**Memorandum
Planning and Urban Development Department
Planning Division**

To: Steve Bushey, PE, Deluca Hoffman
From: Bill Needelman, Senior Planner
Date: November 27, 2012
Re: Canal Landing NewYard: Site Plan Review Notes
CC: Barbara Barhydt, Development Review Services Manager
Dave Margolis-Pineo, Deputy City Engineer
Tom Errico, PE, TY Lin
David Senus, PE, Woodard Curran
Marge Schmuckal, Zoning Administrator

The following notes are based on the October 31 submission of the Canal Landing NewYard Final Site Plan application for a boat repair, storage and brokerage at 40 West Commercial Street. These notes and comments are in addition to review comments provided or to be provided by the City Department of Public Services, the reviewing traffic and stormwater engineers, the zoning administrator, Fire Safety, and other city staff.

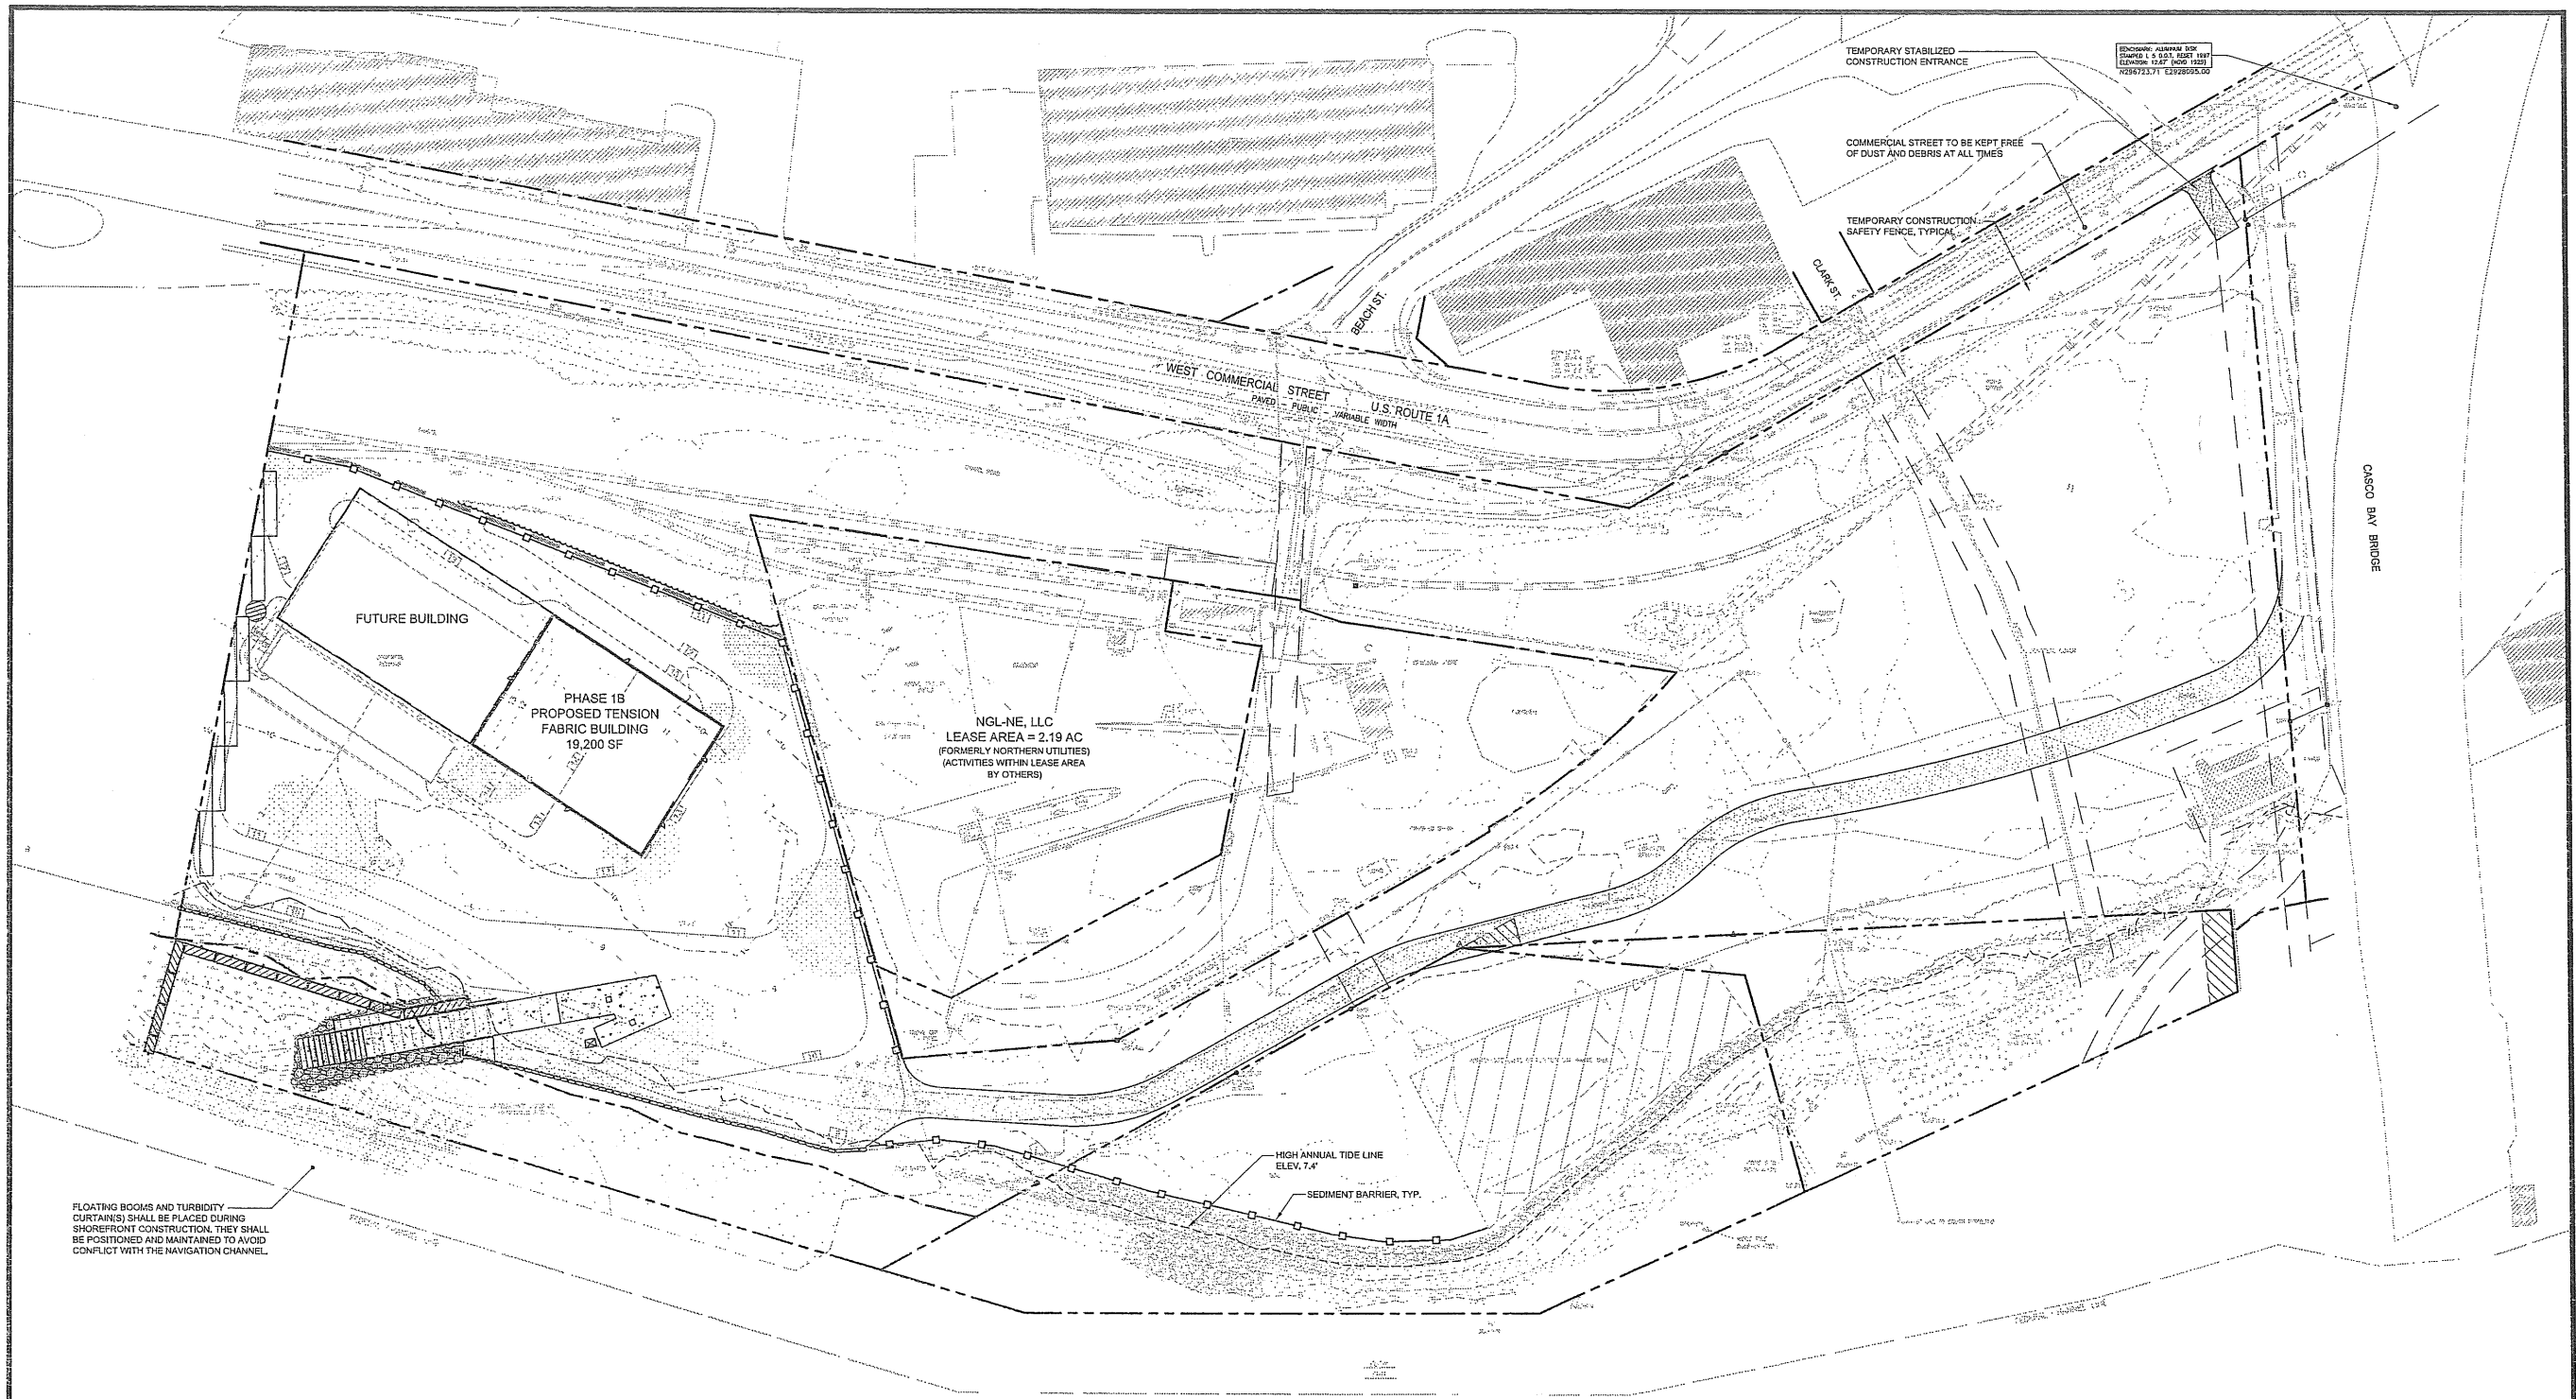
- Page 3-5 Public Infrastructure: Utility Easements: Department of Public Services is requesting utility easements over the CSO crossing the site to the Fore River.
Hydrants and water lines: Applicant indicates that additional hydrants will be provided, but the utilities plan does not show either water lines or additional hydrants.
